Your Ref: OWPC25526
Our Ref: EP/160/19/PL 04-12-2019
Please ask for:
Zac Denton

Demolish redundant external store and former outside toilet at rear of 43 Sea Road and construct a single storey extension to create a 2 bedroom apartment.

Land to the rear of 43 Sea Road East Preston

GROUND FLOOR PLAN 1:100 @ A3 / 1:50 @ A1

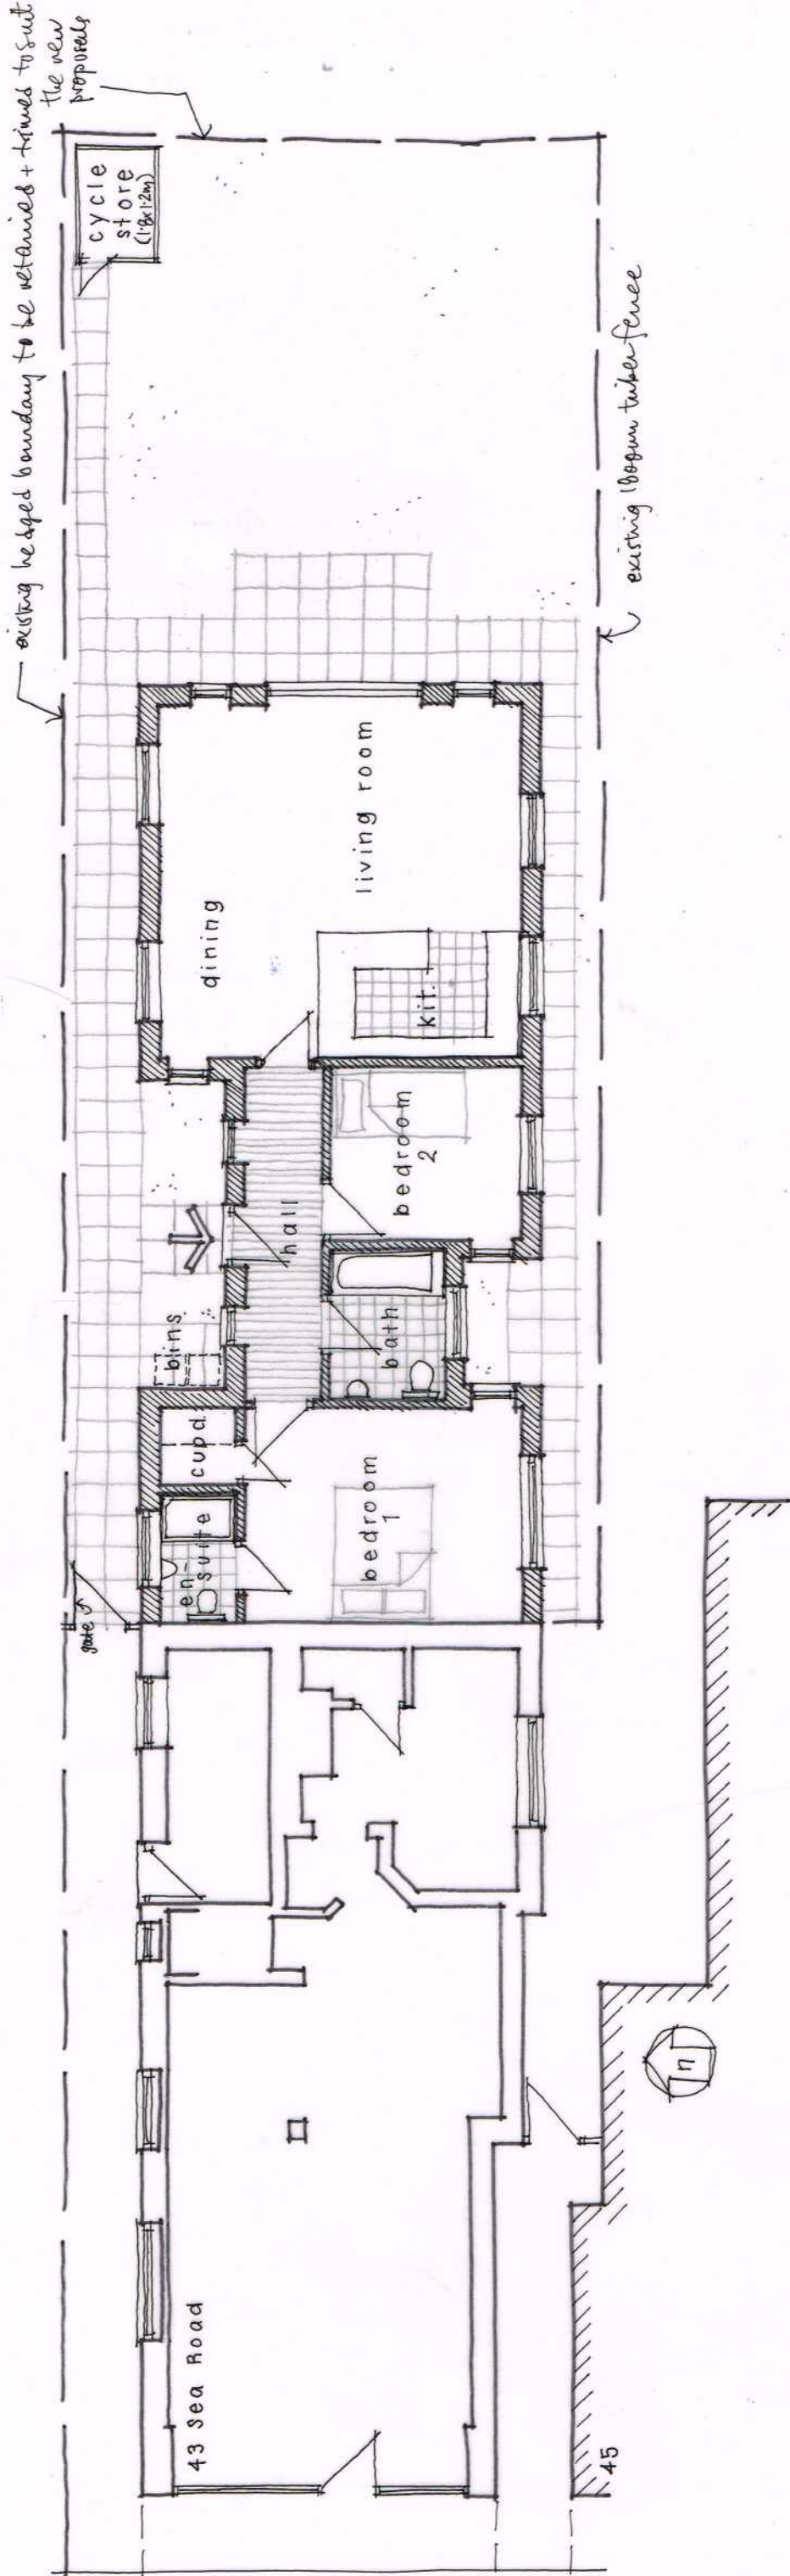
The existing small store is set back from the boundary line (4m) and does not infringe on the garden. This proposal brings the building upto 0.1m of the boundary line and extends well beyond the existing building by circa 12m.

The windows just 1m away from the enclosed garden include 2 bedrooms, hallway bathroom and kitchen - seven open windows in total with a further 4 beyond. This application would have a negative impact to the personal space the existing garden provides and therefore we object to the proposed application.

PROPOSED ELEVATIONS

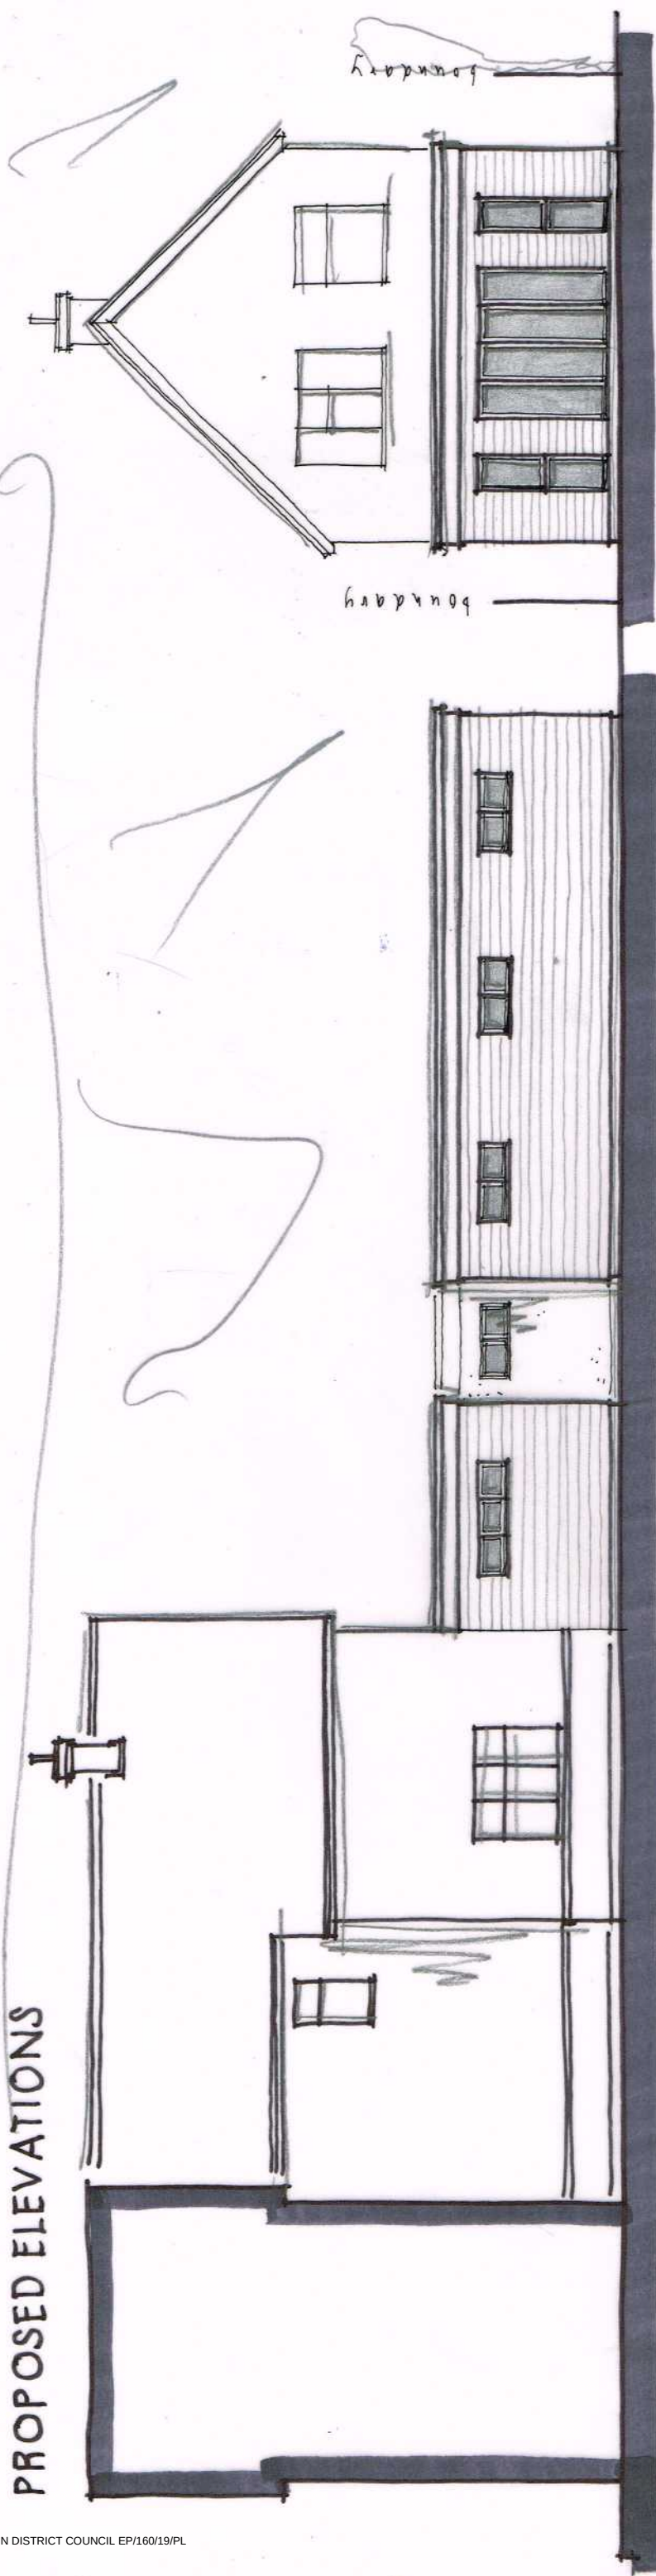
This proposed building although single story would totally over shadow the garden and would make it feel very oppressive.

The windows we note are at high level but the light and potential noise and smells from the kitchen particularly would be an issue.
